# Green Hill Solar Farm

## EN010170

### Change Application 2 and Supporting Environmental Information Report

Document Reference: CR2/GH9.6  
The Infrastructure Planning (Examination Procedure) Rules 2010  
Rules 8(1)(c)

Drawing file: published-documents / EN010170-001492-GH6.4.4.10_C_ES Figure 4.10_Landscape and Ecology Mitigation Plan A_Revision C (Tracked).pdf

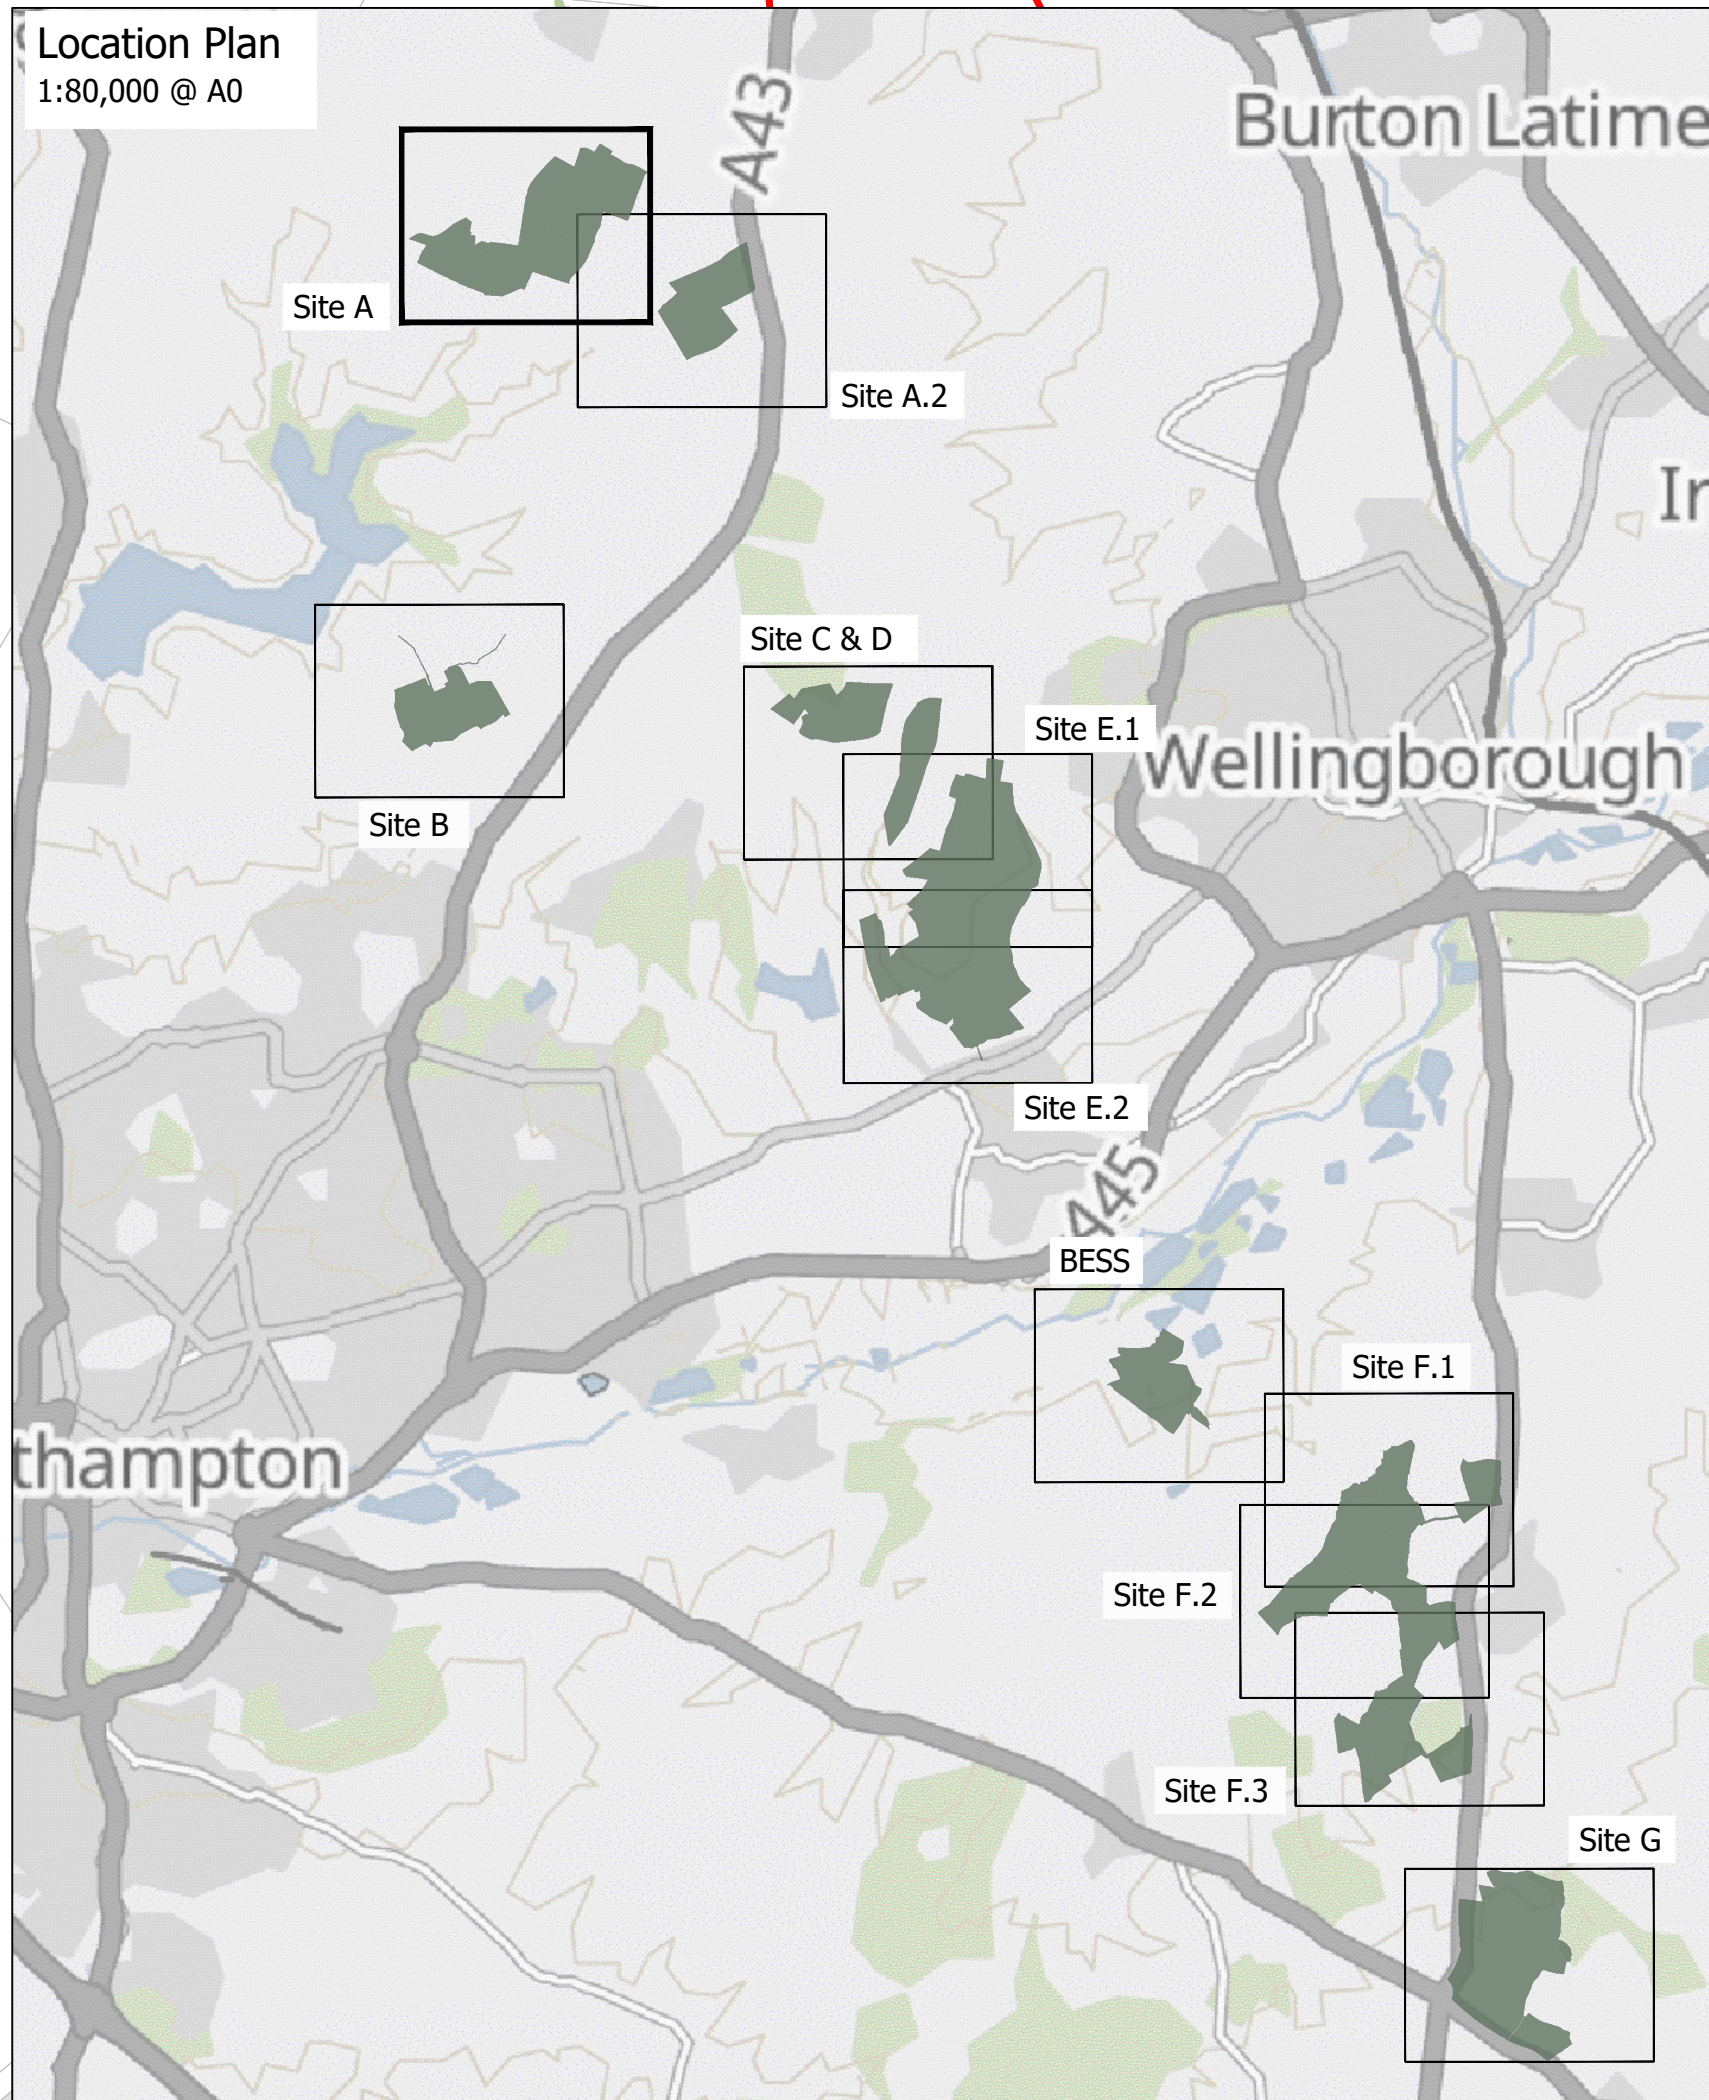
### **3.5 Change 4: Removal of Panels (Work No.1) and reduction of Work No. 1(d) from field AF29 and replacement with biodiversity mitigation and enhancement (Work No 9)**

3.5.2 The Applicant has reviewed this recommendation and has accepted the majority of the suggestion as Change Four. As shown on the **Works Plans [CR2/GH2.4\_E]**, Work No. 1 has been removed from field AF29 and the area of Work No. 1(d) has been reduced to the northern section of AF29. An area for Work No. 1(d), being the electrical and communications cabling between the solar arrays and onsite substations, is required in this field to enable connection between fields AF10 (west of Newland Road) and AF14 and AF28 (east of Newland Road). These cables will be laid below ground and therefore do not require any increase hedgerow height as mitigation, identified by the Examining Authority as a key concern underpinning their suggested change. Field AF29 is now proposed for biodiversity mitigation and enhancement under Work Nos 6 and 9.

3.5.3 AF29 has been changed to ground nesting bird mitigation, continued arable land. Section 5.5 of this Report discusses the potential benefits of this change in respect of Skylark mitigation.

3.5.5 Following review of the Examining Authorities comments on the draft Development Consent Order, the following comment was noted, '*field boundary*

*hedges of AF29 could be left at current heights as there would be no alien man-made features to screen*'. Considering the removal of panels in this field; and to maintain the existing openness that exists along the adjacent section of Newland Road and the Permissive Path, through the middle of Green Hill Site A the previously proposed additional tree planting along the eastern and western boundaries of AF29 has been removed. In line with the **Outline Landscape and Ecological Management Plan [CR2/GH7.4\_C]**, the existing hedgerow along the boundaries will be maintained and gapped up (infilled) wherever practicable. The **Outline Landscape and Ecological Management Plan [CR2/GH7.4\_C]** Section 4.3 has been amended to outline hedgerow management requirements for the eastern and western boundaries of AF29.

3.5.6 **ES Figure 4.10 Landscape and Ecology Mitigation Plan A [CR2/GH6.4.4.10\_C]** has been updated to reflect this change.
